**Submission for the Proposed Small Stock Abattoir & Continued
Operation of the Blayney Sealink Cold Store Complex.**

SSD 6594

We are making an **objection** to the proposed development based on the following.

Figure 4 Proposed Blayney Export Meats Conceptual Engineering Design

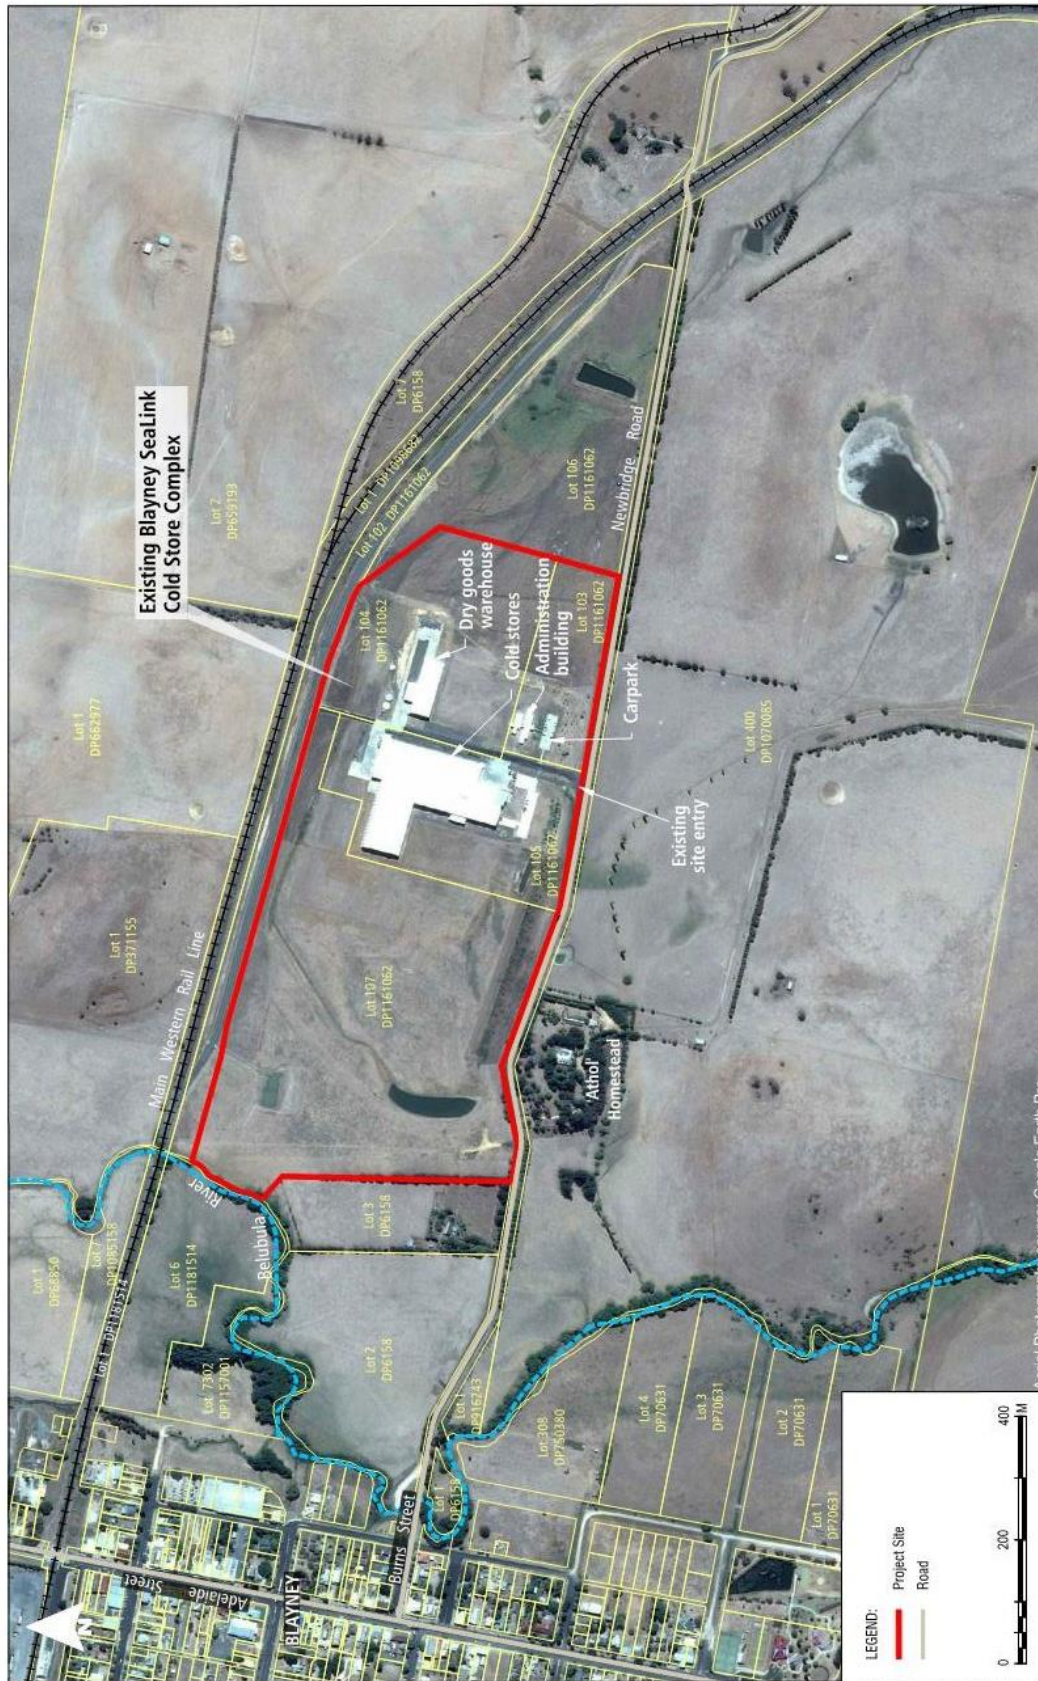
There is no provision in the EIS surface water management conceptual layout (Figure 6.14 p130 EIS) for a stormwater retention dam separate from the existing 3rd order or proposed redirected 3rd order watercourse for overland flows. As stated by Blayney Council the dam would have to have a capacity greater than the existing 11.4 megalitres.

The proposed surface water management conceptual layout (Figure 6.14 EIS p130) does not show any appropriate measures to prevent contaminated stormwater, effluent or wastewater from leaving the 47ha project site.

The proposed changes to the 3rd order watercourse on the project site as shown on Fig 6.14 p130 EIS are:

- Relocation of a section of the open engineered channel to the north of the proposed abattoir footprint. The abattoir building will be 12m approx. from the centre of the proposed new channel.
- Major earthworks to fill and close off the existing section of watercourse flowing to the existing SW dam, the natural drainage pattern and redirect waters to;
- A proposed newly constructed open channel (new 3rd order watercourse). This will direct flows to the existing 4 megalitre dam/basin and then on towards the Belubula river in the NW corner of the project site.
- Extension of formalised channel spillway to the Belubula river property boundary.
- The conversion of the existing SW dam currently on the 3rd order watercourse to a turkeys nest dam will involve more than the minor earthworks stated in the EIS.

The net result is the redirection of the natural drainage pattern of a 3rd order watercourse to enter the Belubula river some 1.65km approx. upstream of its natural entry point.
